Barangaroo – Commercial Building C3, C4 and C5 MP11_0044, MP10_0025 MOD1 and MP10_0227

Response to Environmental Assessments and Modification request
Submission to the Department of Planning 19 December 2011

City of Sydney

19 December 2011

Figure 3: C3 Northern Elevation

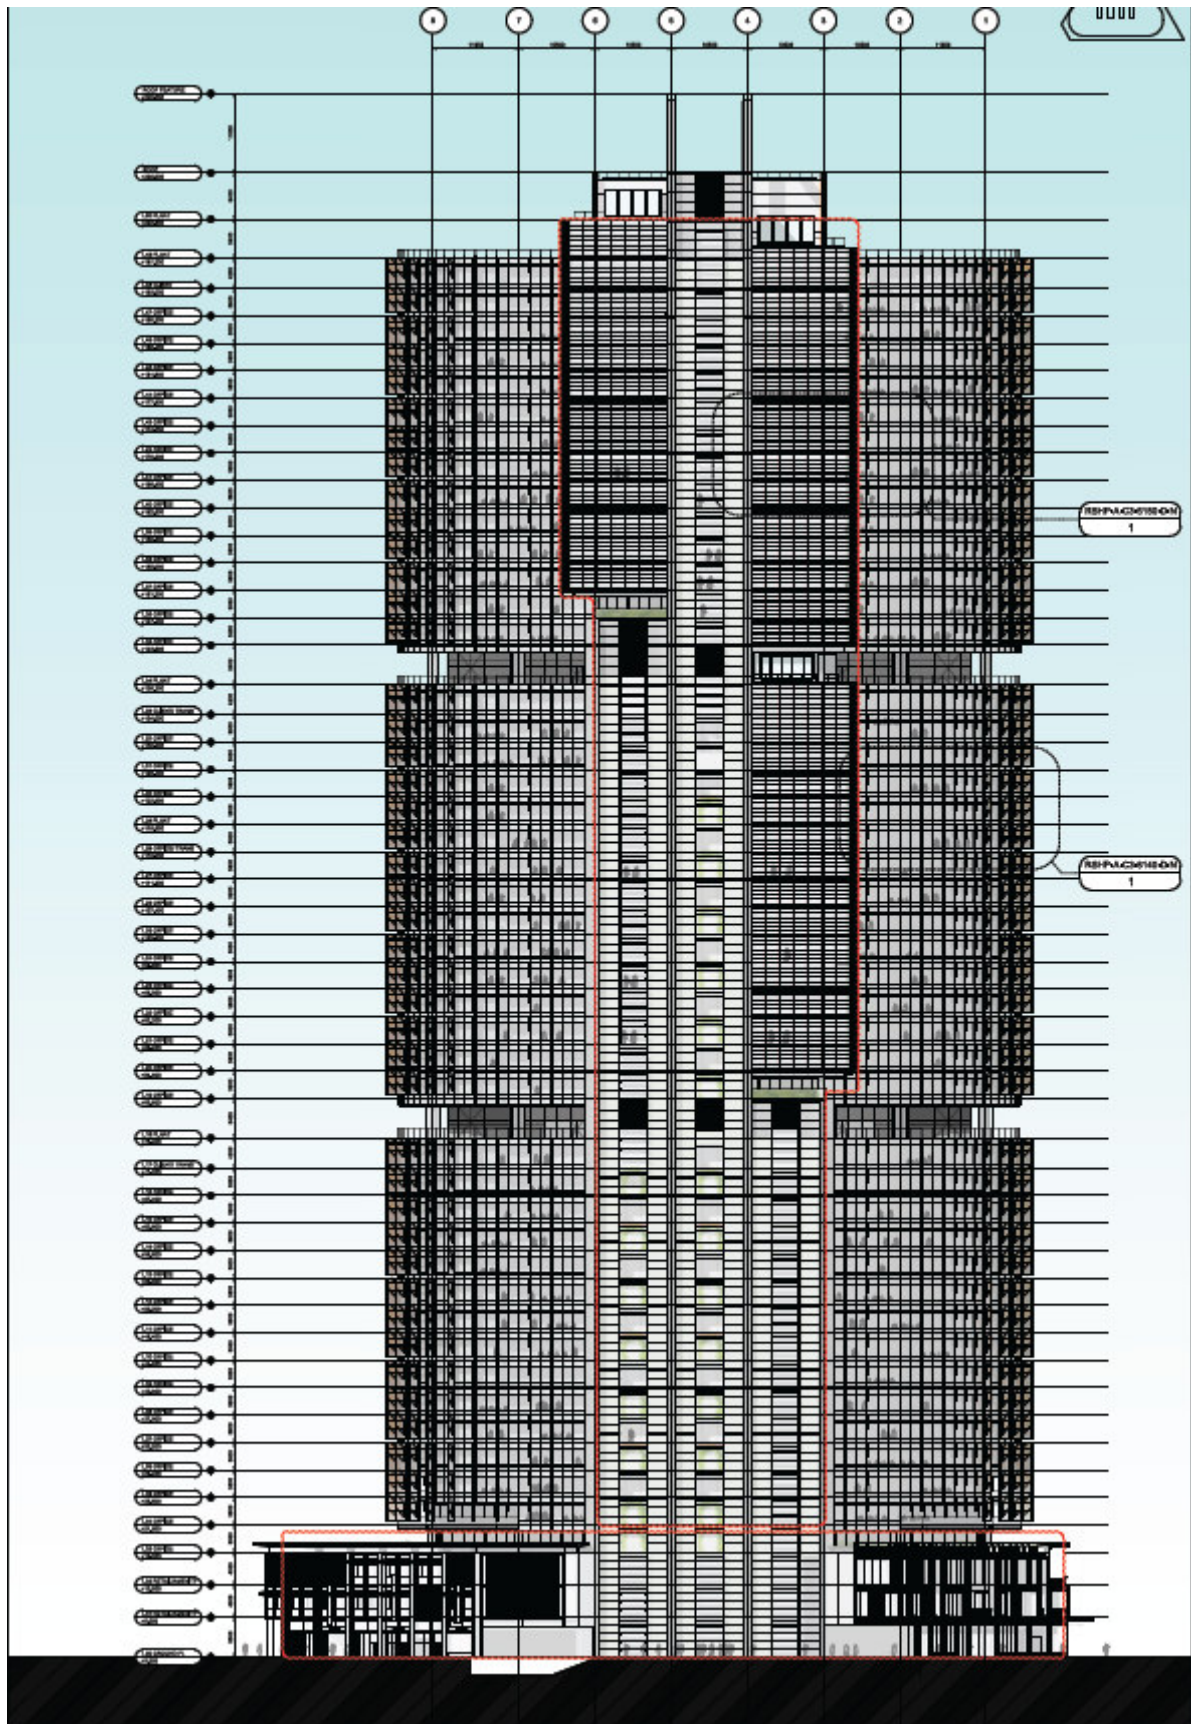
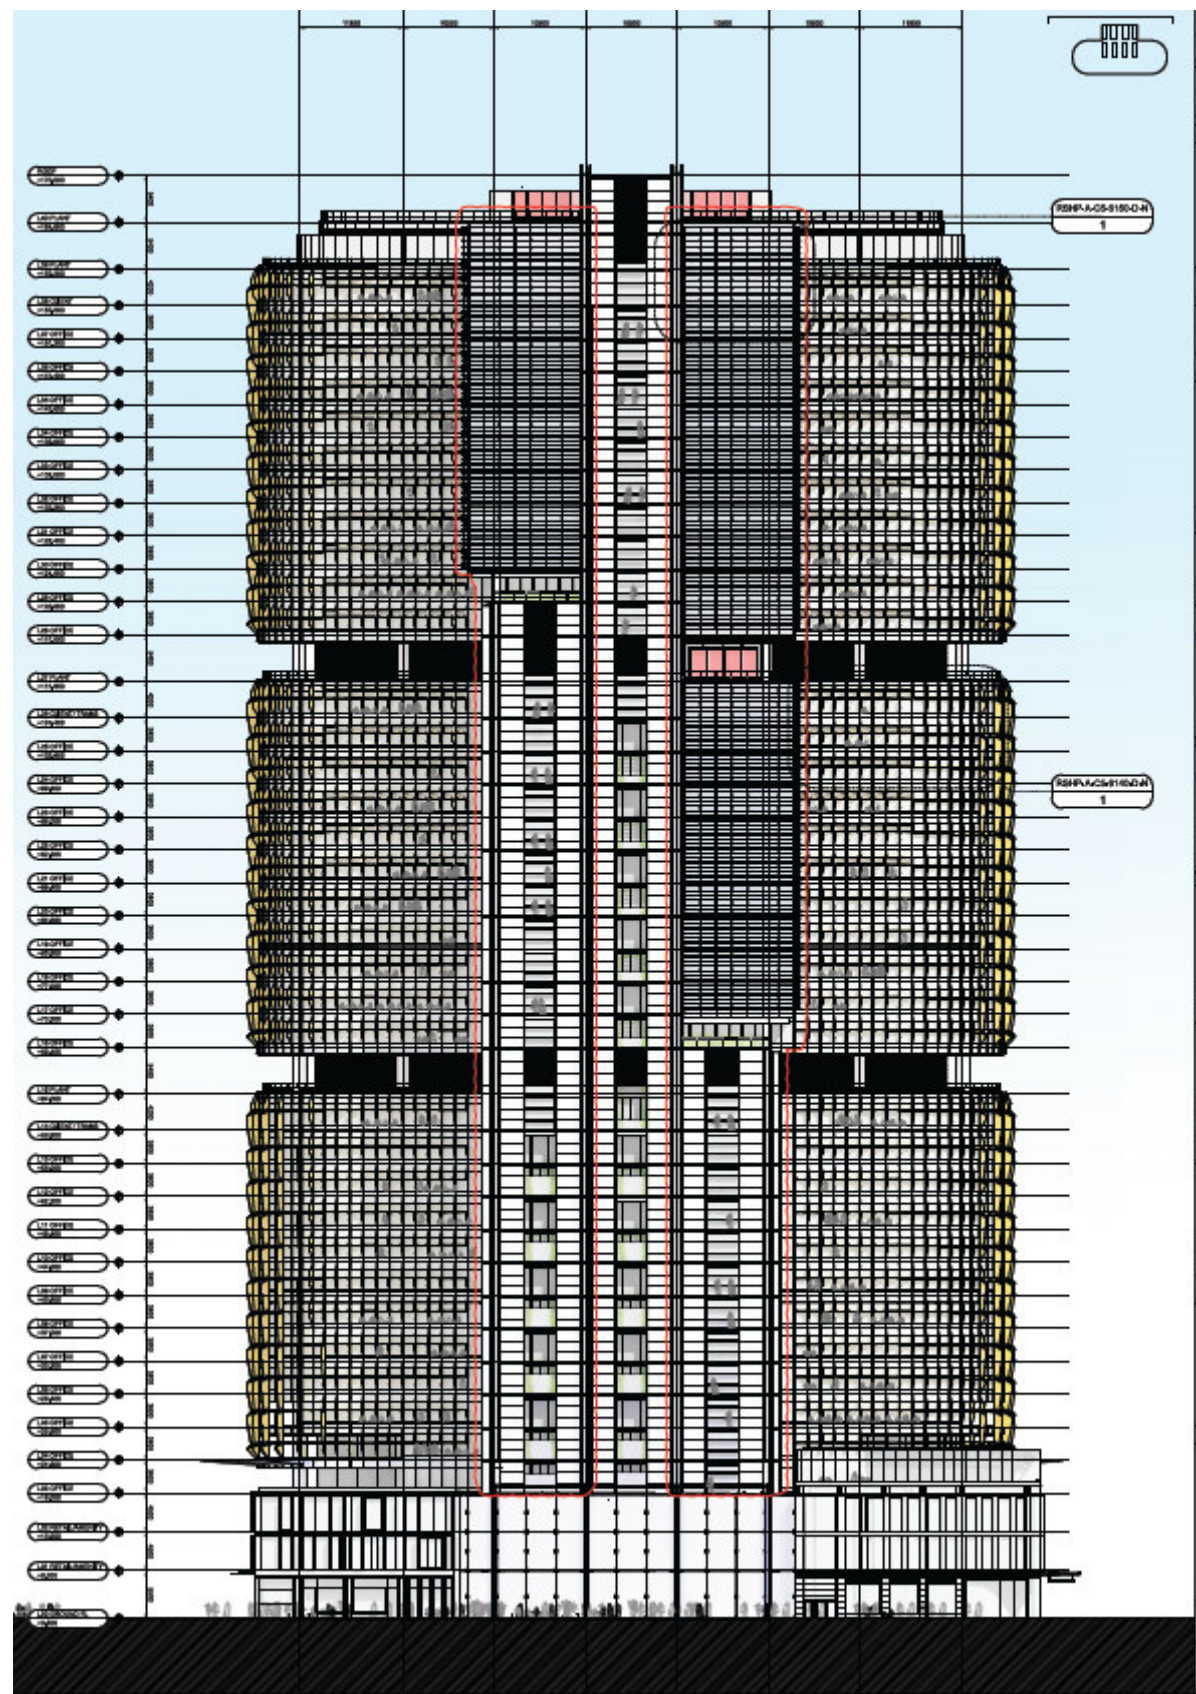
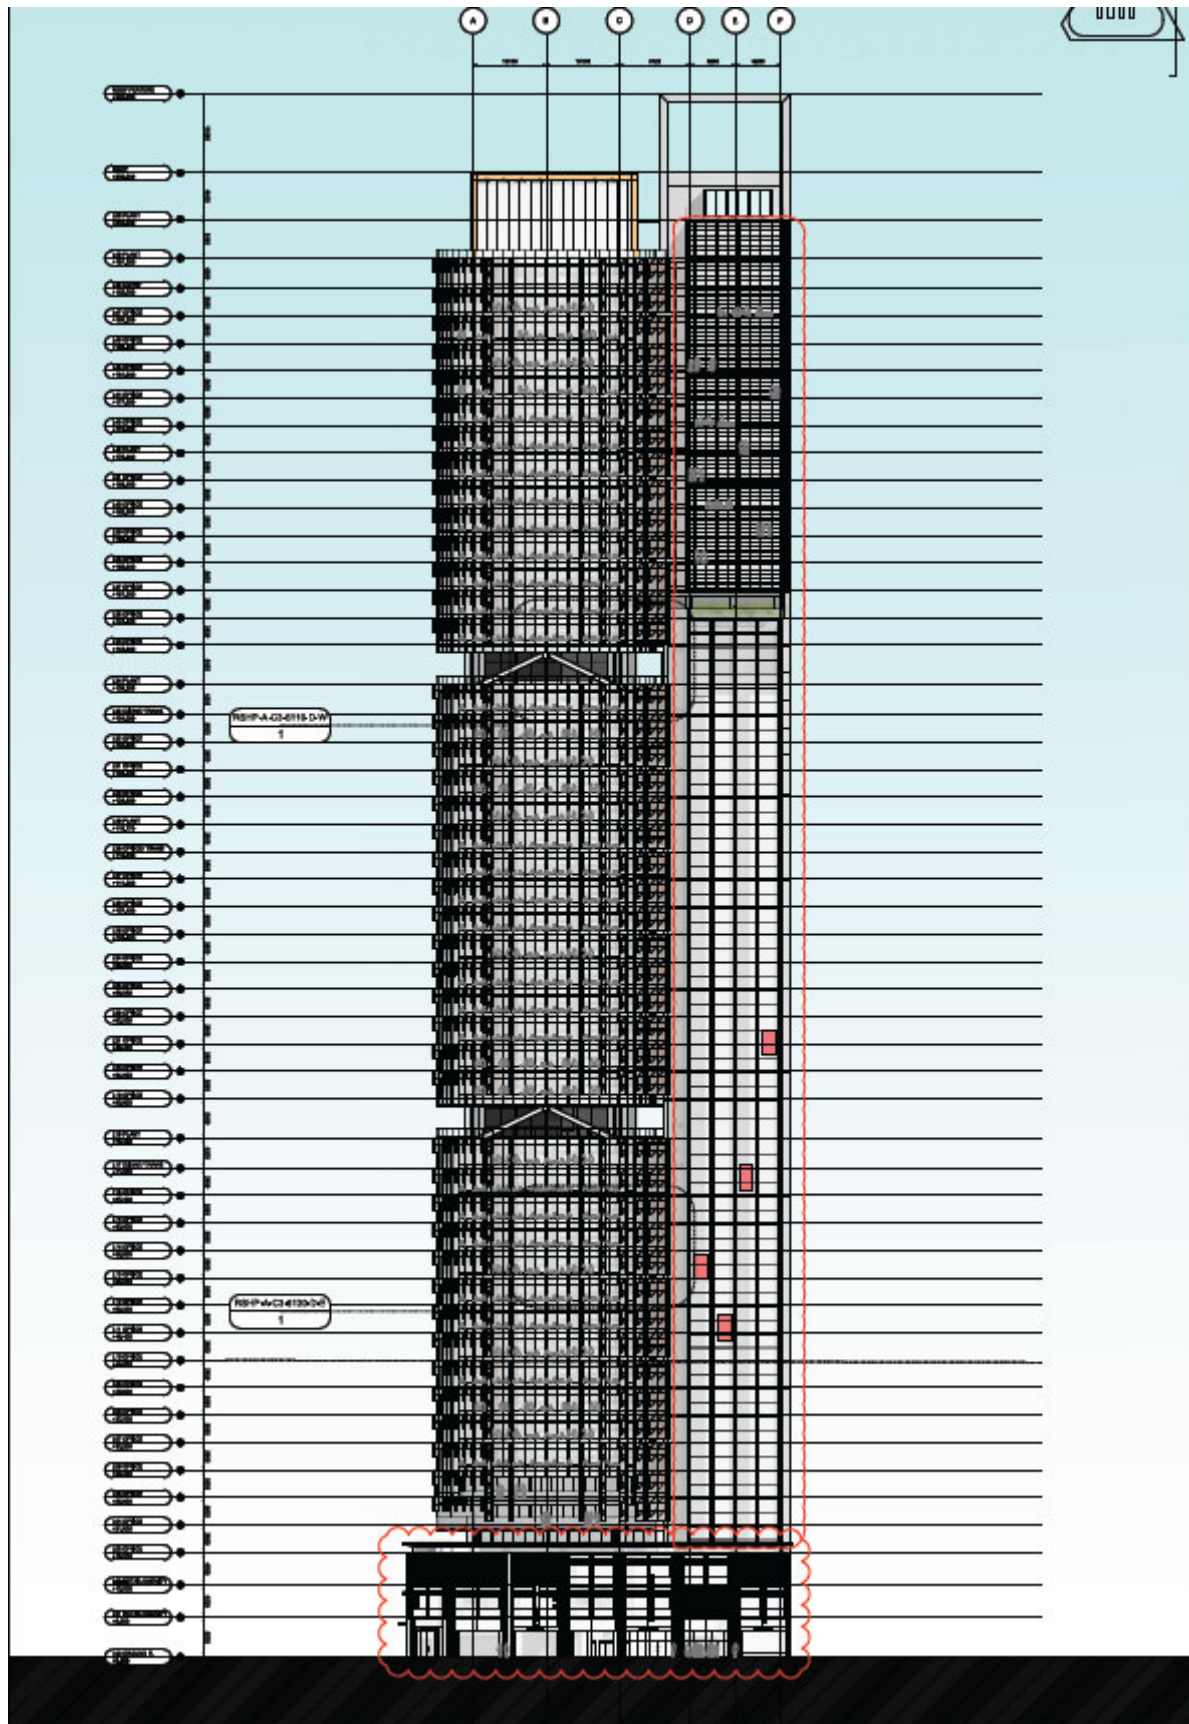
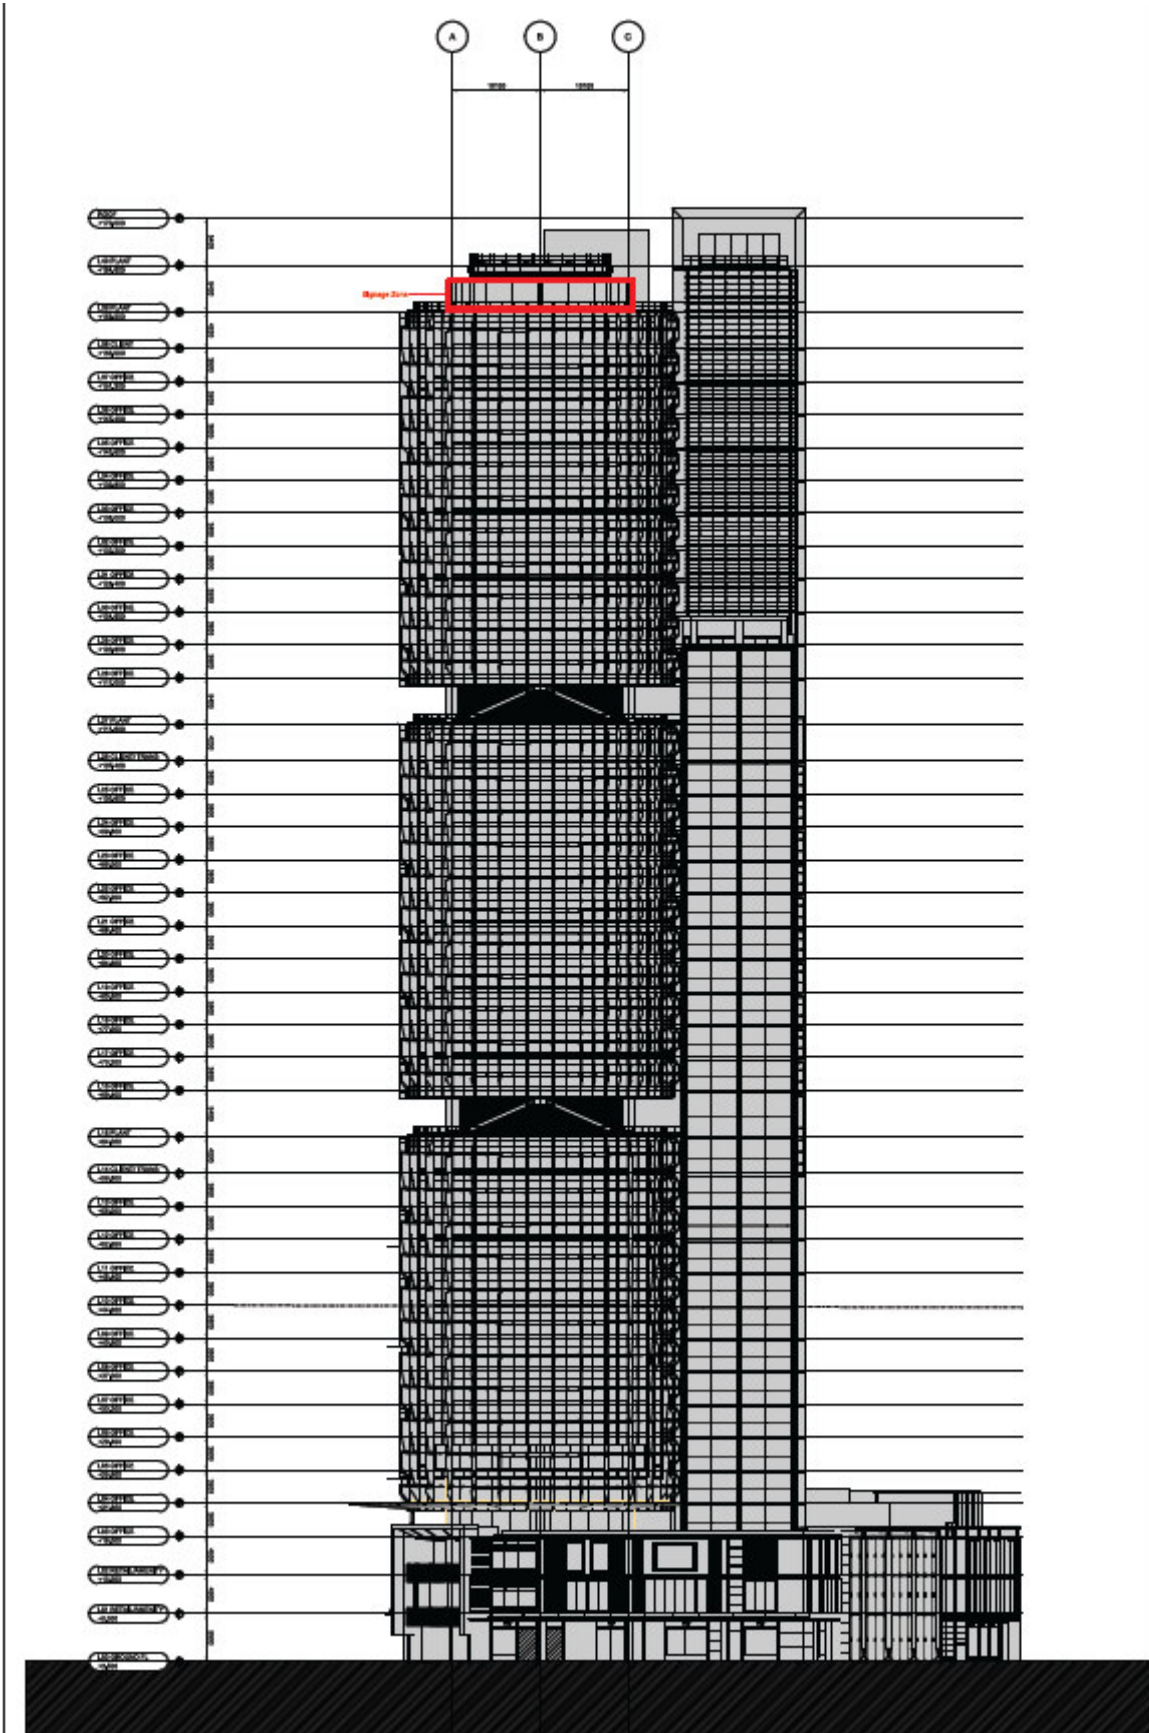
The City reiterates concerns previously identified in Recommendation 5 that the proposals do not go far enough in addressing the bulk and scale impacts. In particular, it is considered that C5 should have a maximum height of RL140 (5 floors) to improve ground plane conditions. The three main reasons being that this will help to improve wind impacts, improve overshadowing particularly to areas of the harbour and harbour foreshore and also to reduce the bulk of the building. This forms new Recommendation 5A below.

- C5 should be lowered to a maximum height of RL140.

Figure 7: Photomontage of C3, C4 and C5 when viewed from Pyrmont

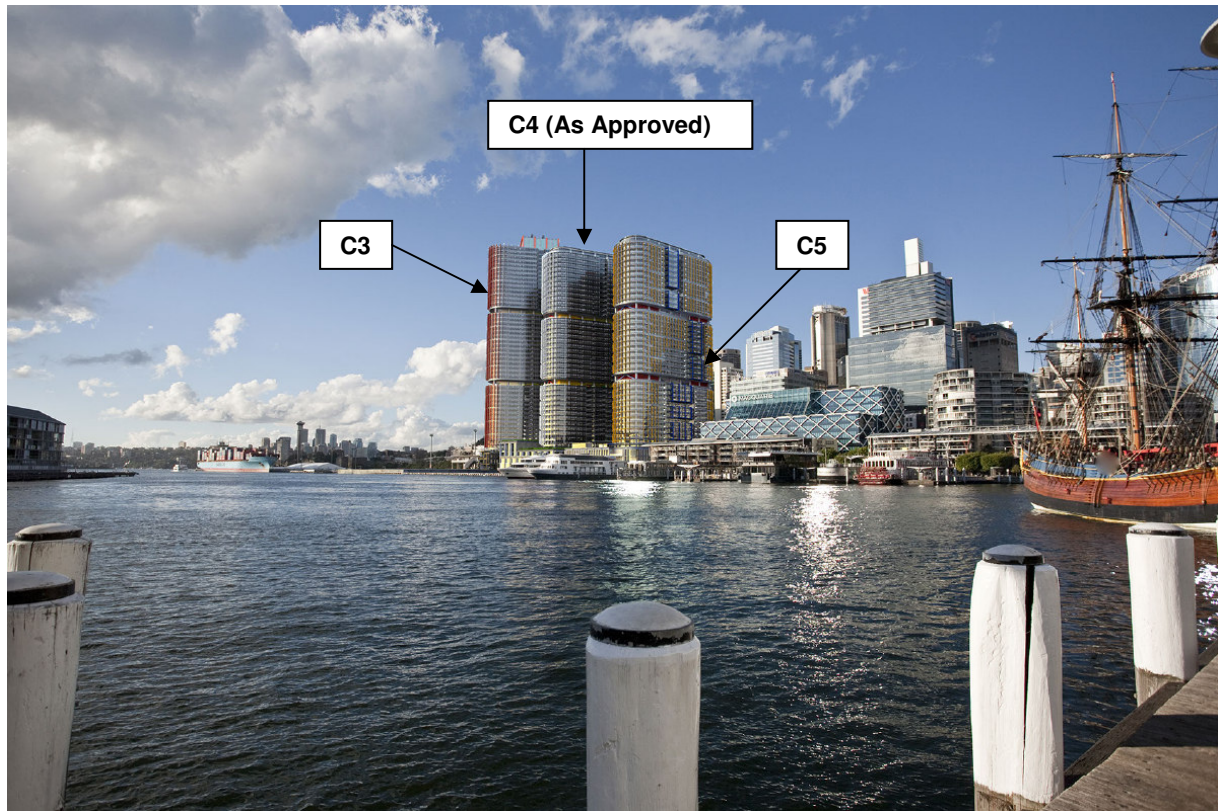
The City has noted that most of the photomontages view the buildings from above street level. One exception is Figure 9. The City rejects much of the photomontage methodology using wide angle lens (to replicate field of vision instead of human eye perspective) and recommends that new photomontages of all 3 towers together be requested, particularly as viewed through Union Walk.
